Our Ref: AW/310/11/NMA

Application AW/310/11/NMA for non-material amendment following grant of planning permission AW/52/11

SOUTH ELEVATION (FRONT OF HOUSE)

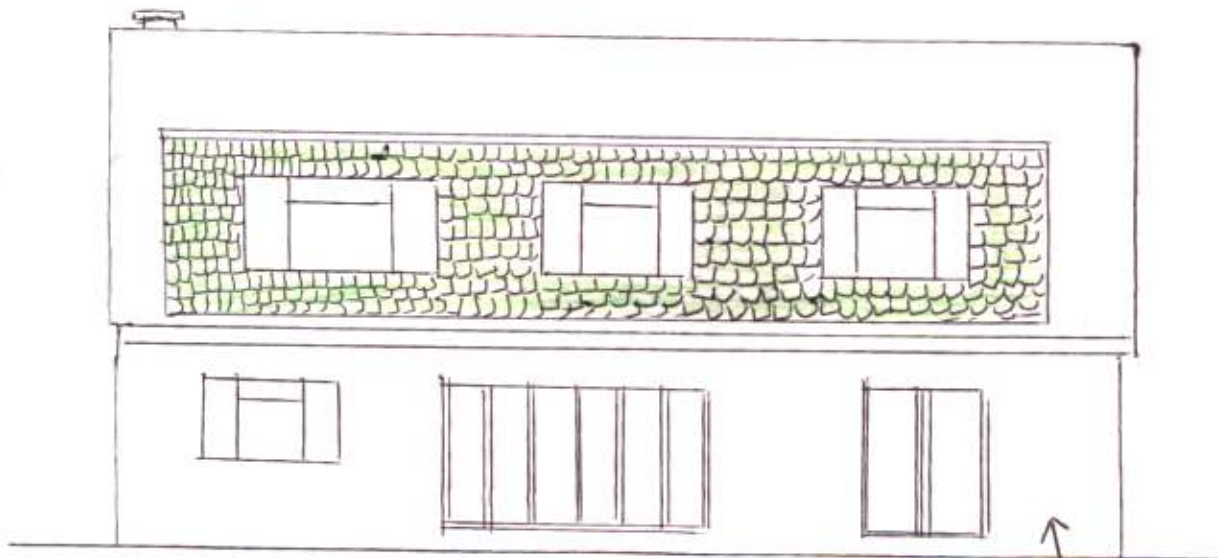
The change of brick to white render on the rear extension and the use of off white/cream eternit cladding in lieu of green tile hanging to the pitch roof front dormer and balcony recess, can be accepted as a Non-Material Amendment as shown on the submitted drawing. This now becomes the approved plan for AW/52/11.

Please note that these plans therefore become the approved plans for planning application AW/52/11.
